**Subject: Request for Modification to the Section 404 Individual Permit and Section 401 Water Quality Certification for I-485 (Charlotte Outer Loop) from east of I-77 to I-85 in Mecklenburg County. Division 10, TIP's R-2248 E and R-2123 CE, Debit \$570 from WBS 34410.3.GV2**

**Reference: USACE Individual Permit Action ID SAW-2011-01237, dated Nov.22, 2011.  
NCDWQ Water Quality Certification No. 003868, dated October 14, 2011.**

**R-2248 E – Roadway Portion of Future I-485 between I-85 and NC 115**

Permit Drawing  
Sheet 51 of 108

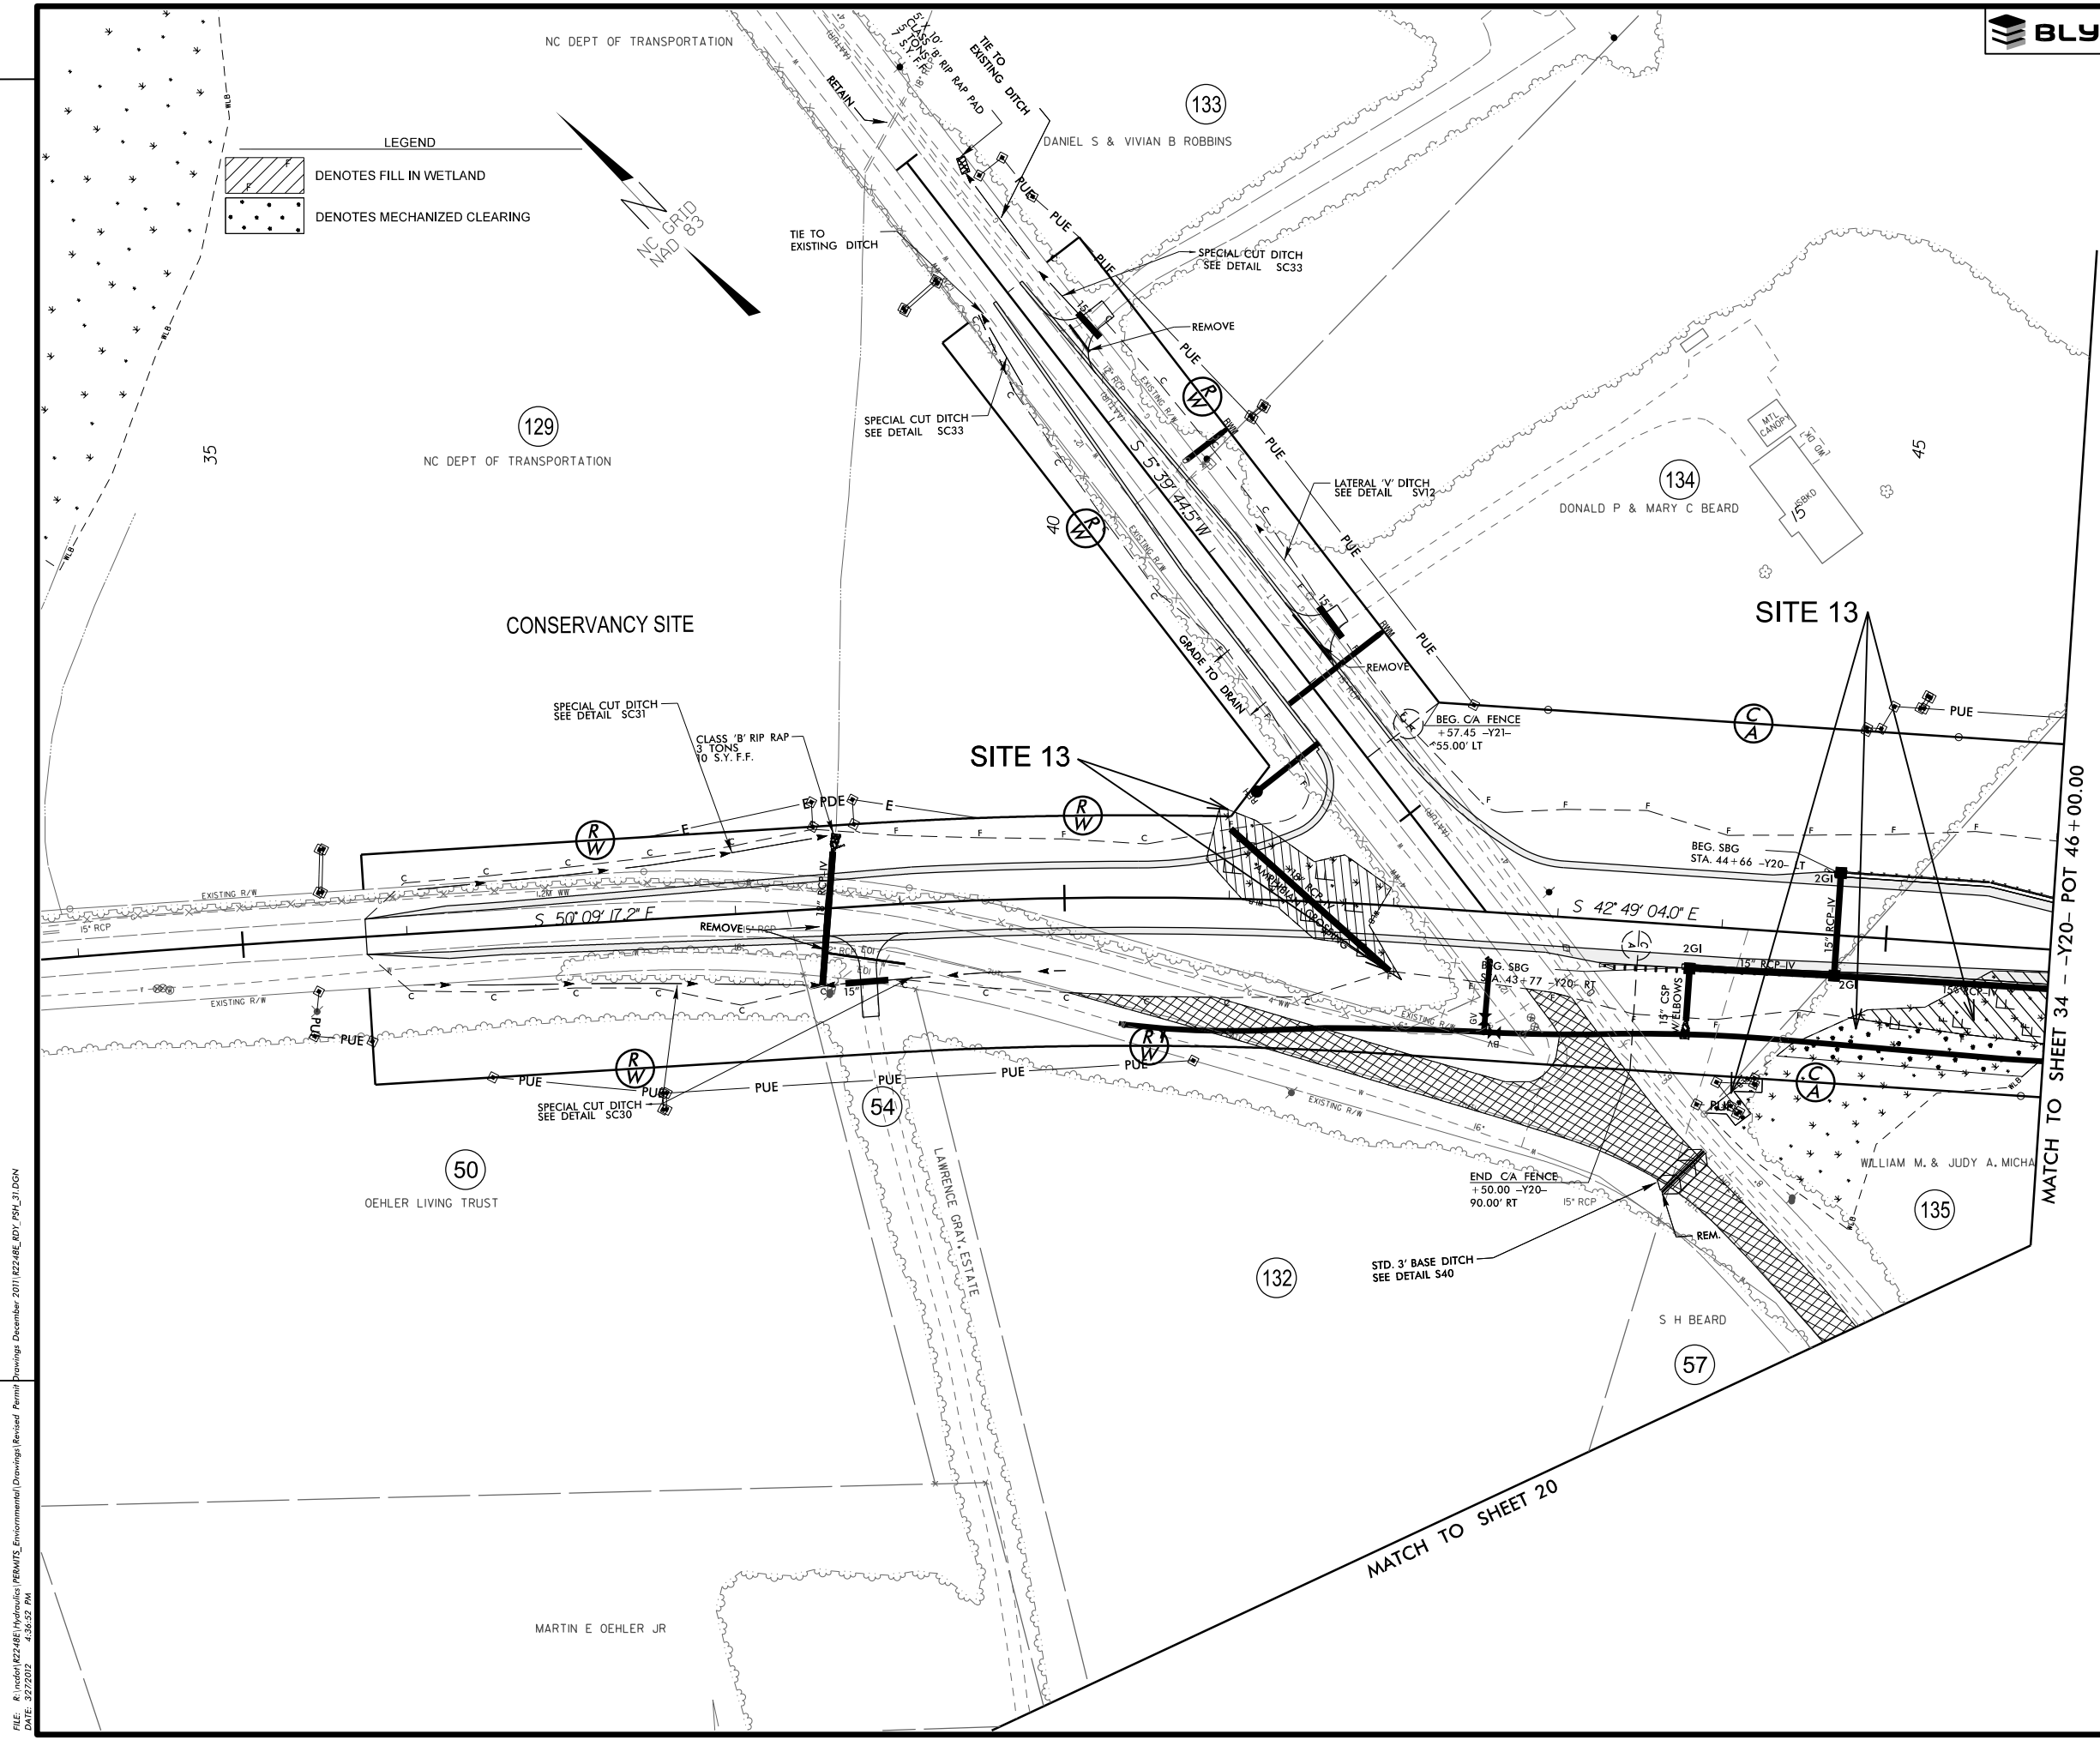
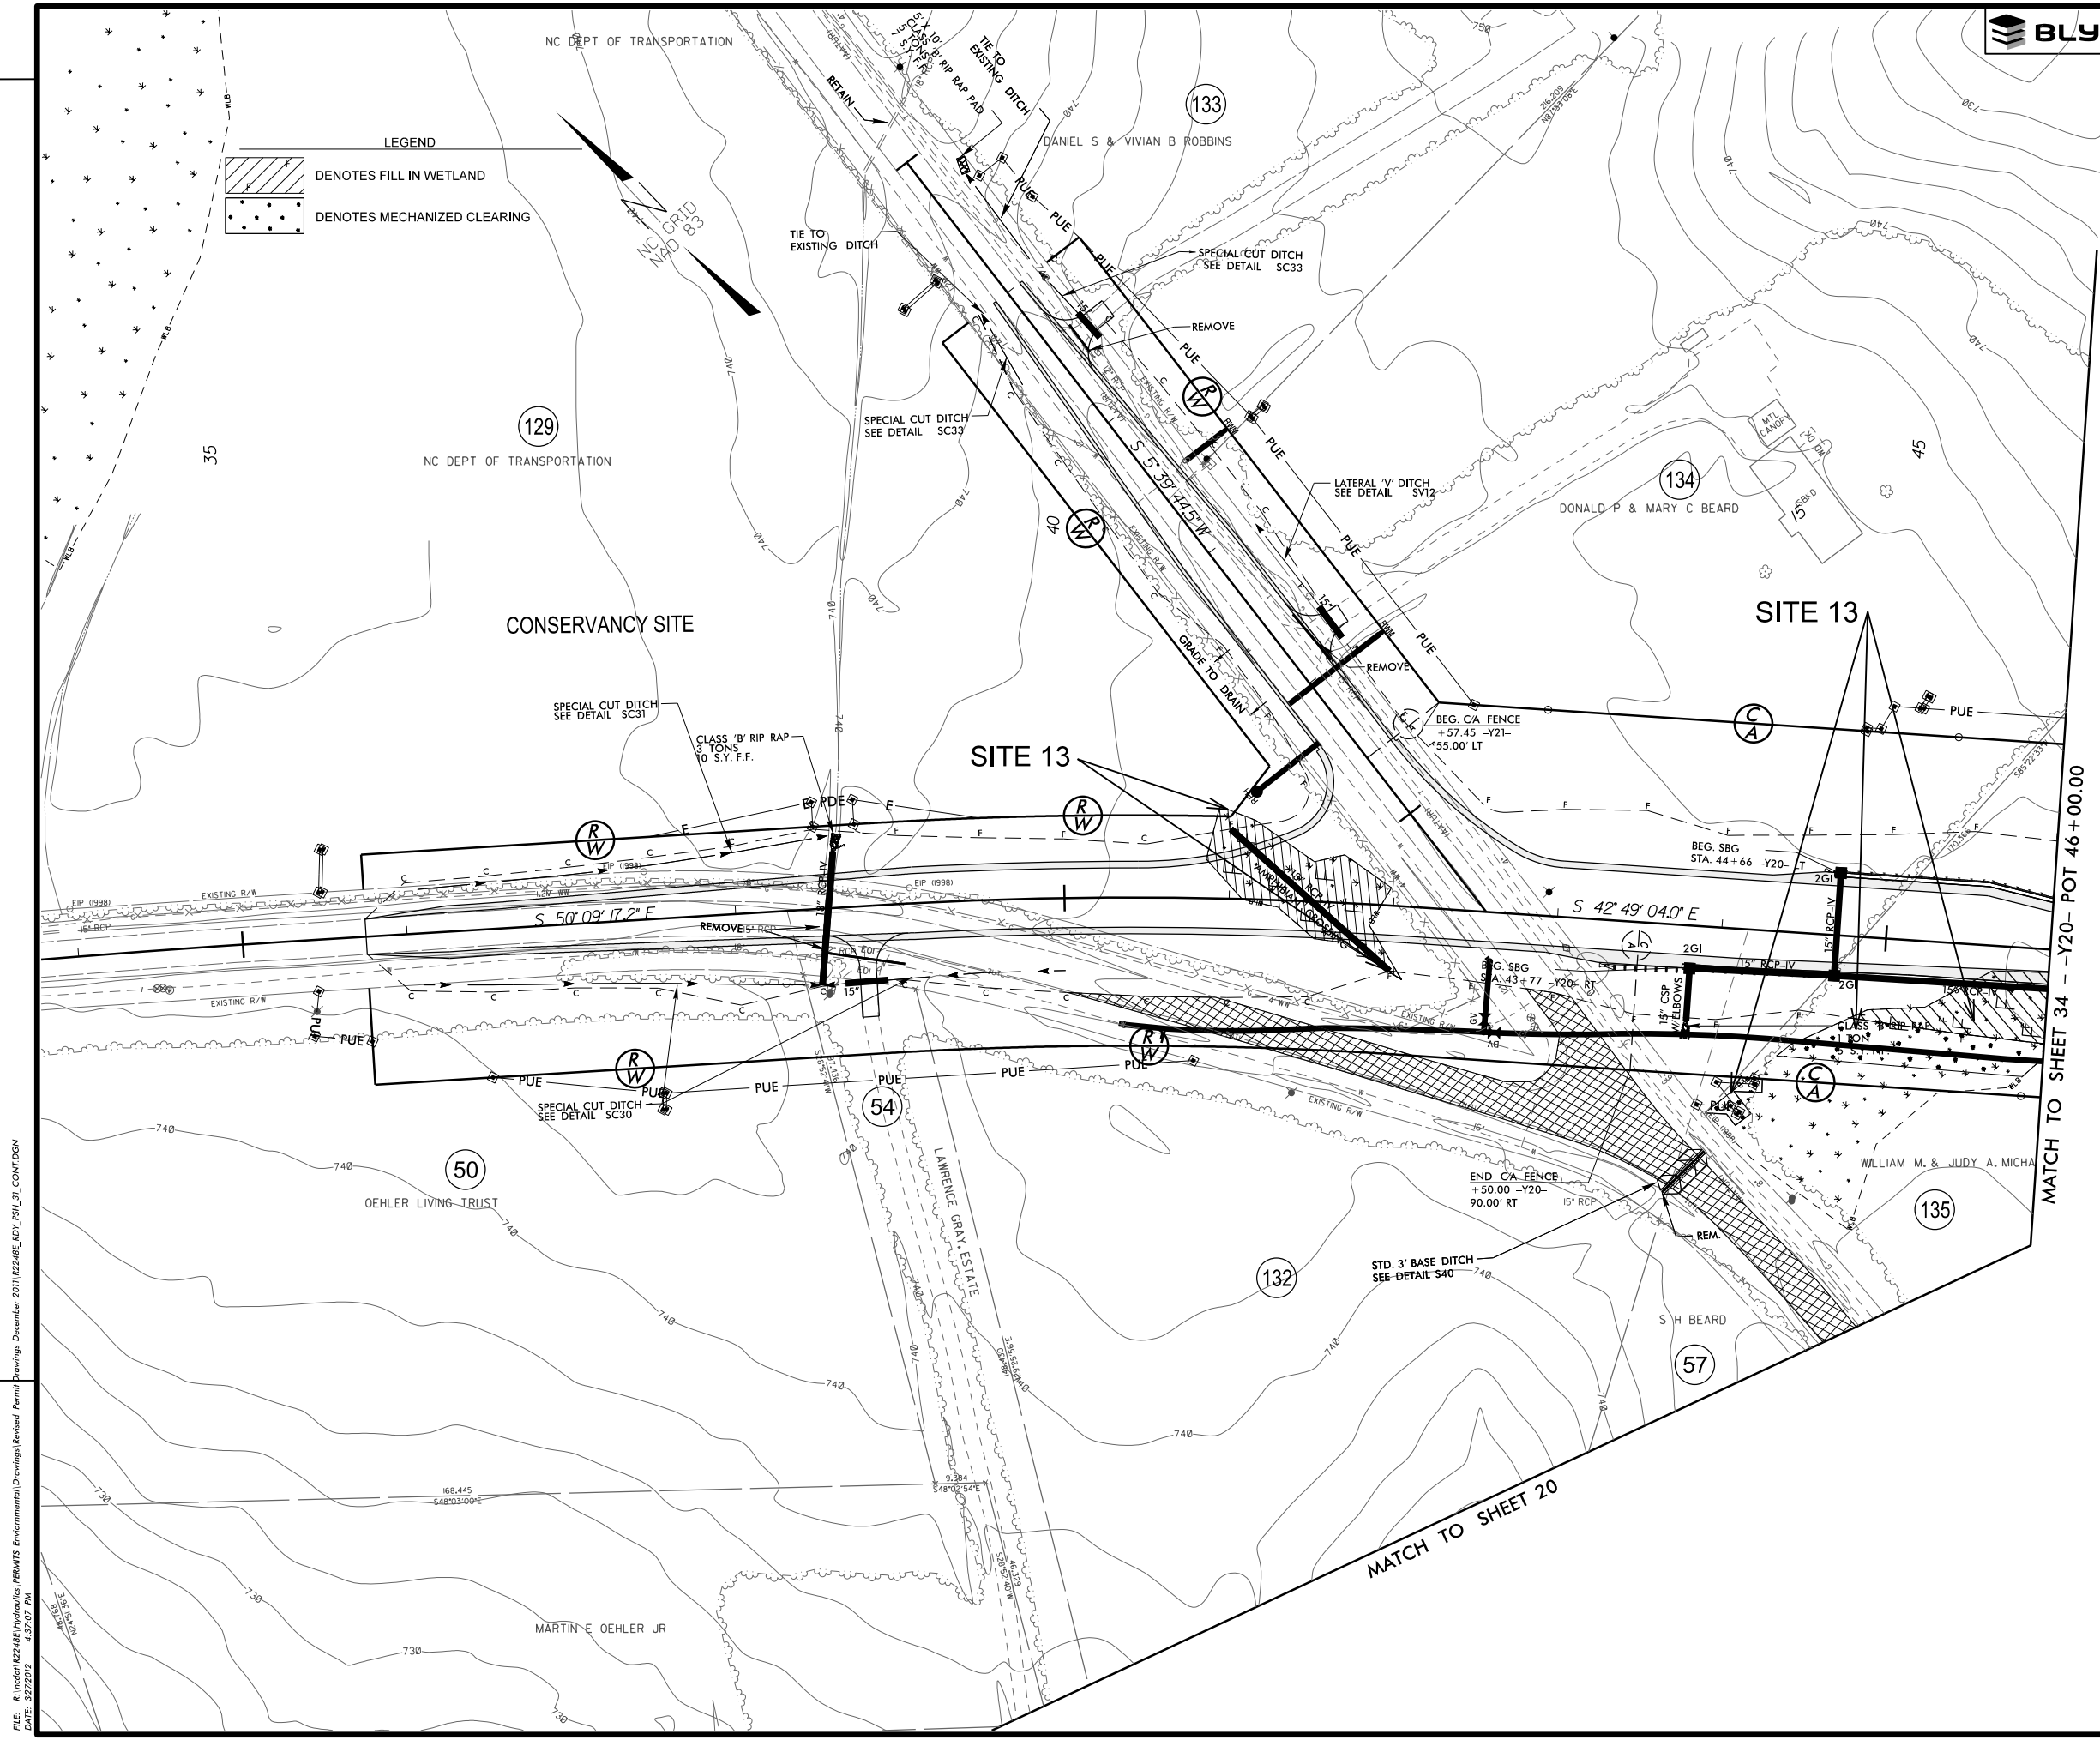
**Revision:** A new water line will cross portions of wetland WO. Utility pole guy-wire anchors will also result in impacts to wetland WO.

**Reason:** Water line and utility pole guy-wire anchors added, south of Y22.

**Impacts:** Impacts to wetlands WL and WP have not changed. The alignment of the water line was placed as close to the fill slope as possible, in order to minimize impacts to WO. Water line installation must occur prior to construction of Y20, which precludes placing the water line under the future fill slope.

Mechanized clearing of wetland WO has increased by 0.09 (0.08 acre for water line installation, 0.01 acre for guy-wire anchor installation).

Excavation in wetlands has increased by 0.03 acre (due to installation of water line and installation of guy-wire anchors).

Within the wetland area to be mechanically cleared, a 15-foot wide corridor centered on the water line will be maintained as an access for future repair and maintenance. The wetland type conversion (forested to herbaceous) within this 15 foot-wide corridor will result in an area of 0.05 acre to be maintained as herbaceous wetland.
